DEVELOPMENT APPLICATION T6-13-248
LOT 2 SEC 20A DP759080, 119 RIVER STREET WEST KEMPSEY
KEMPSEY HOSPITAL REDEVELOPMENT STAGE 1

Thank you for the opportunity to comment of the redevelopment of the Kempsey Hospital.
Please find below Council's comments on the EIS:

DRAWING
EARLY WORKS
PHASE 2A DRAINAGE PLAN
SHEET 2

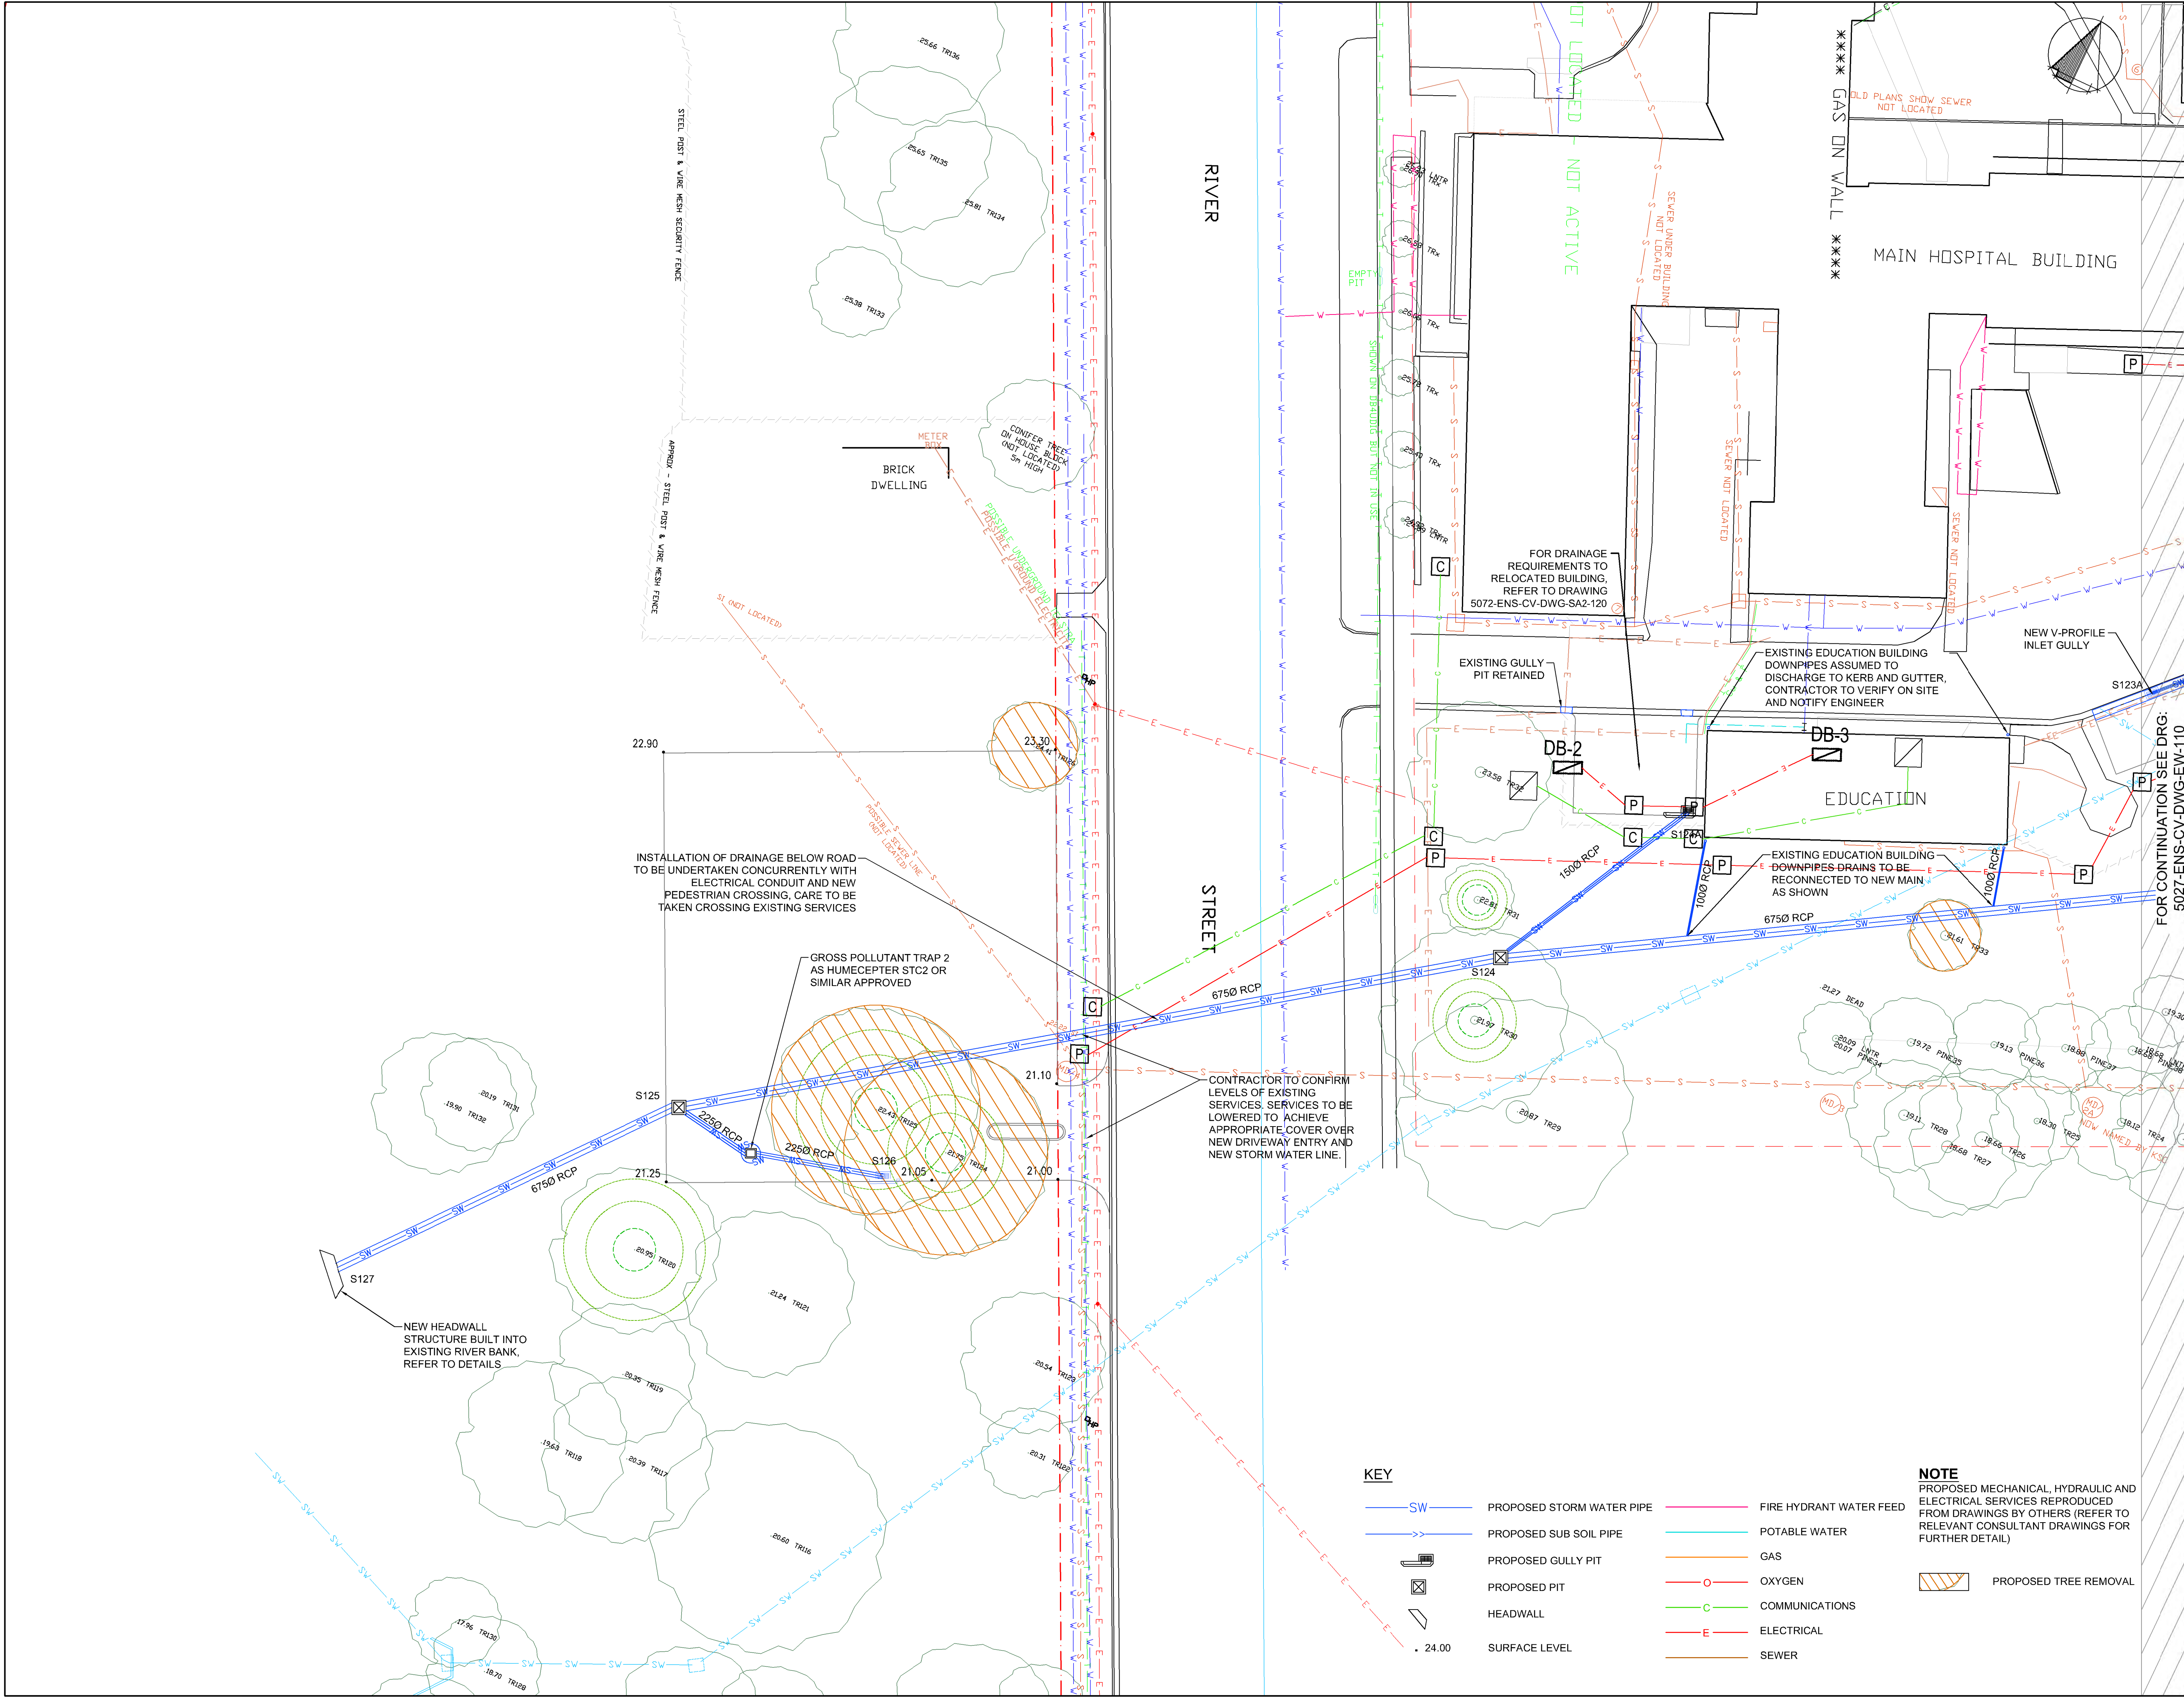
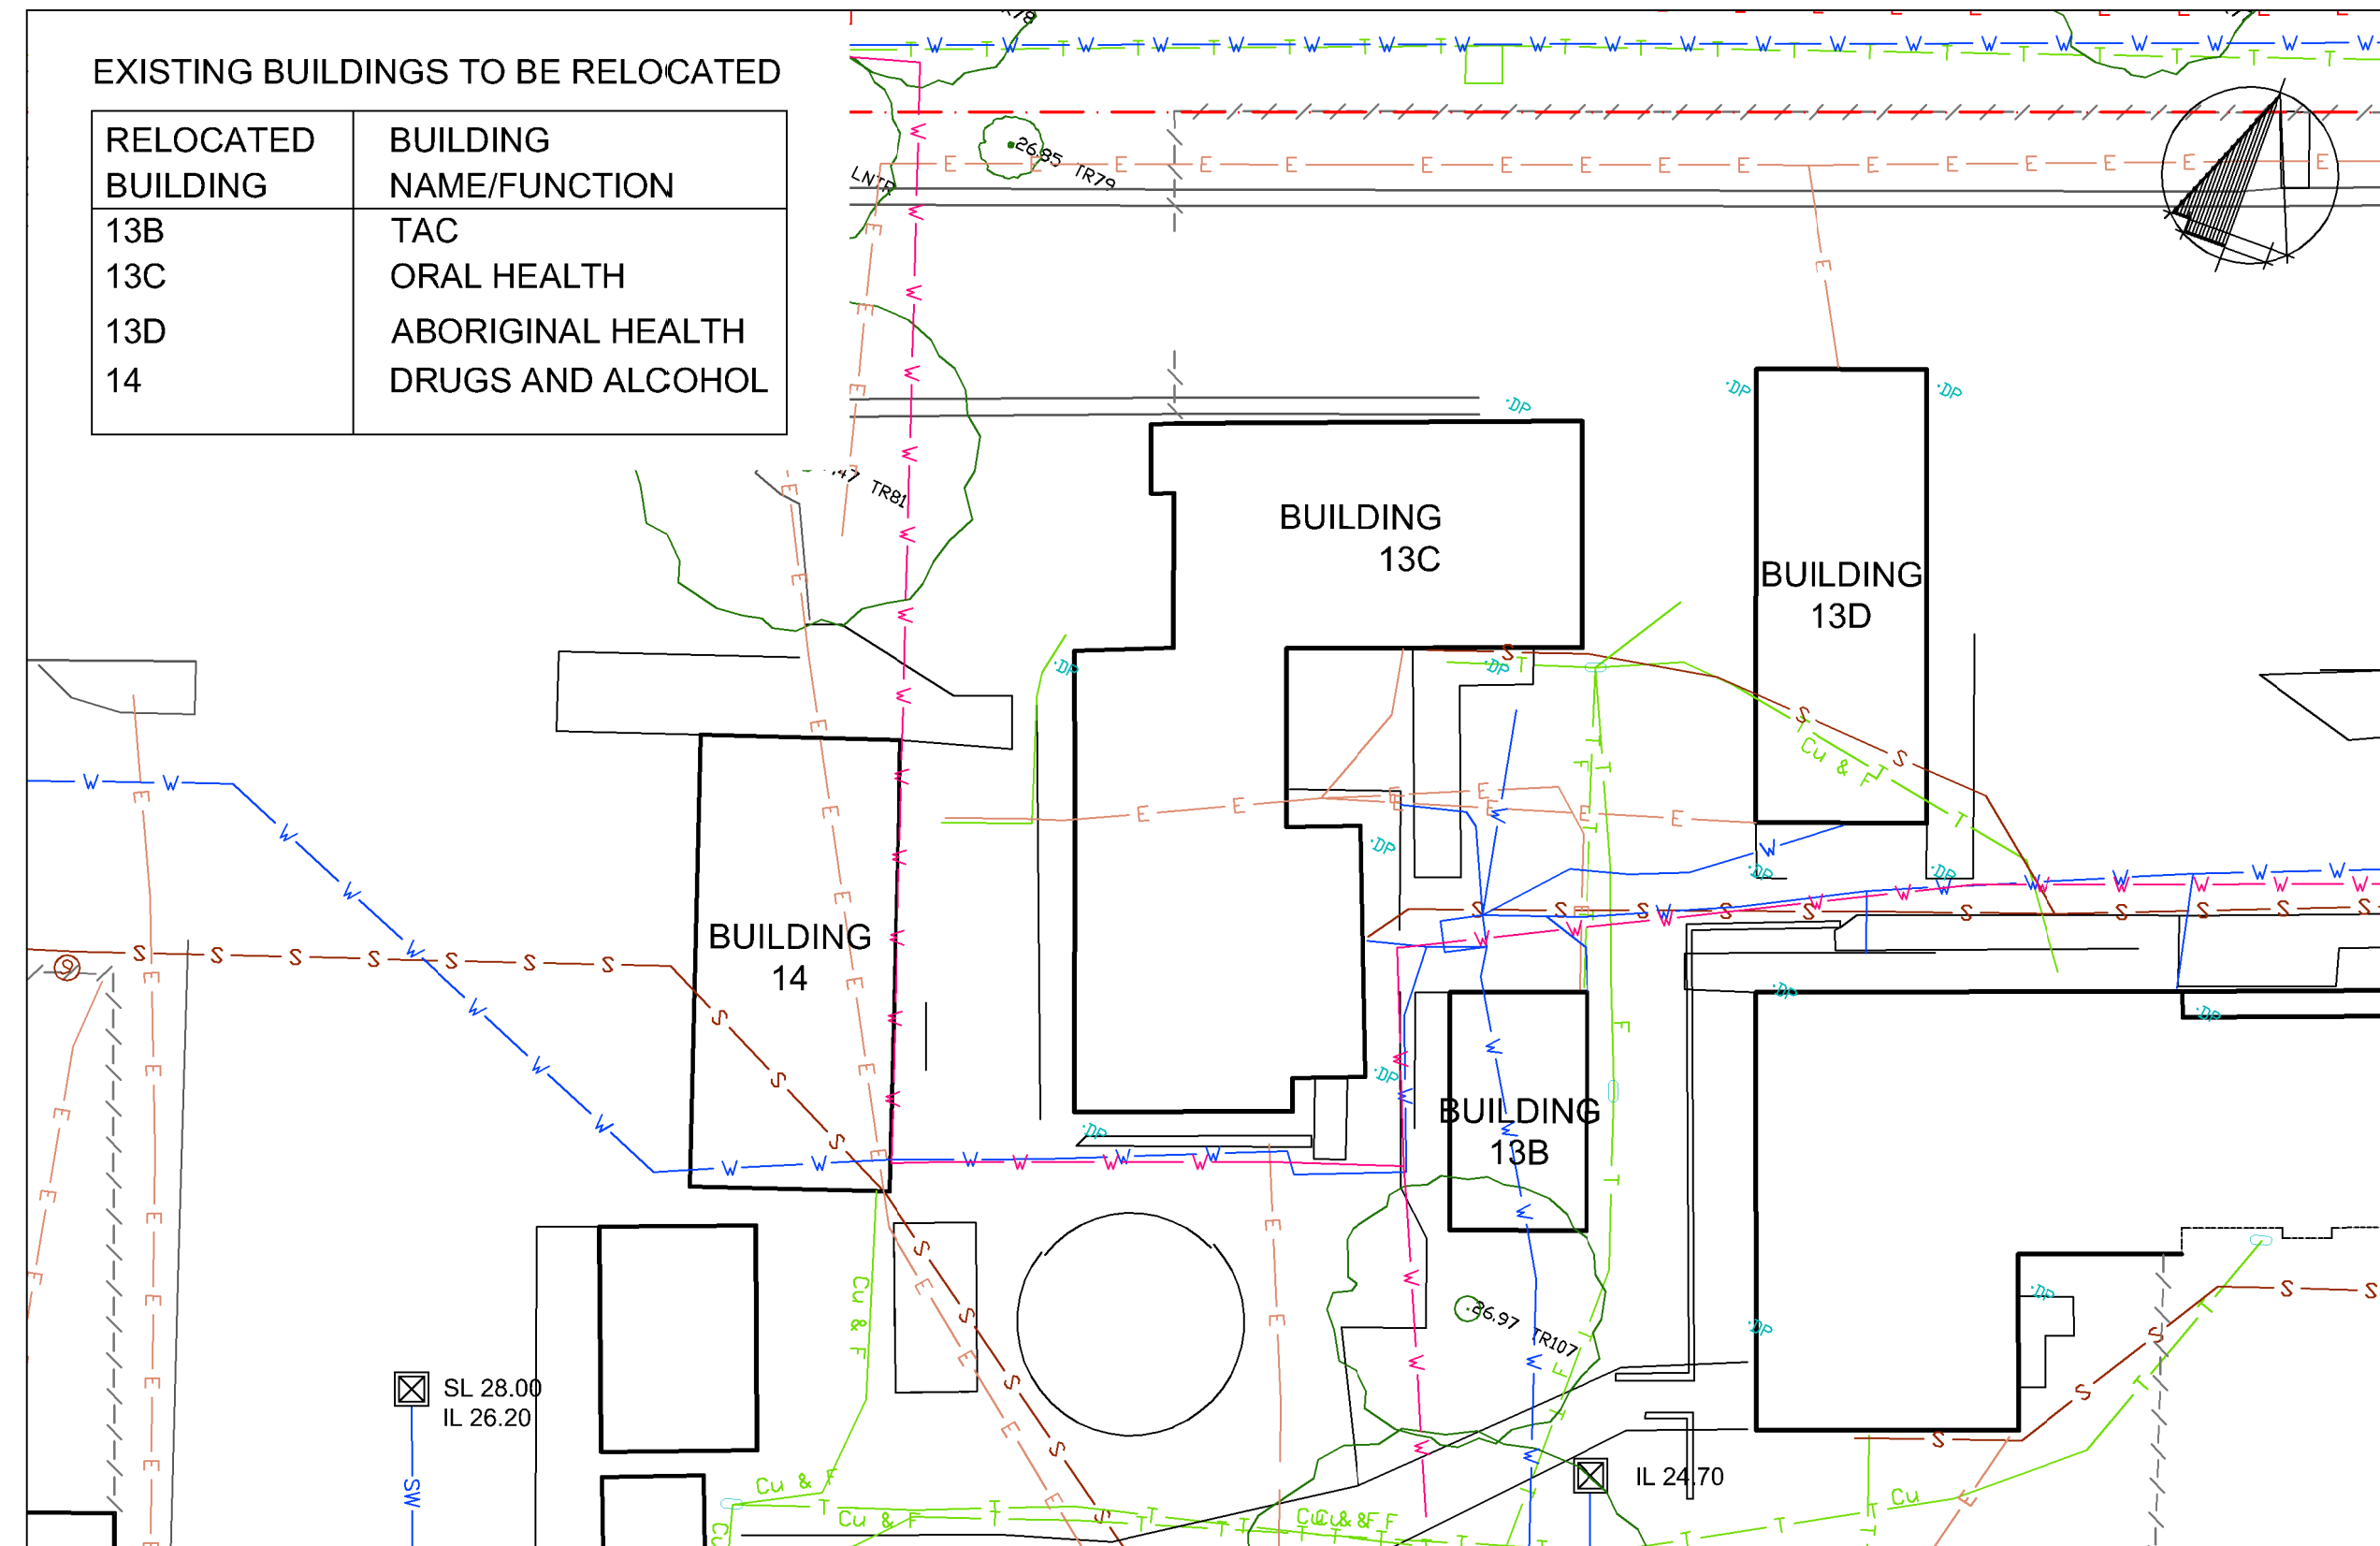
4.15.2 Stormwater Management Strategy	<ul style="list-style-type: none">There is no reference to the Enstruct's <i>Stormwater Management Plan</i> (SMP) at appendix K2;There is no mention in either the SMP or the EIS on water quality targets and means of achieving them, only that a gross pollutant capture system will be installed prior to discharge to the Macleay River which does not address water quality discharge from the site as a whole;There is no discussion anywhere in the EIS

SUBJECT	COMMENTS
	<p>or supporting documentation on the location of the proposed new piped stormwater drain outlet at the Macleay River and the method to be deployed to reduce the outlet velocity in the pipe to prevent scour at the river bank;</p> <ul style="list-style-type: none">• There are no details on the effect on the existing environment (flora and fauna habitat) at the proposed pipe discharge point at the Macleay River;
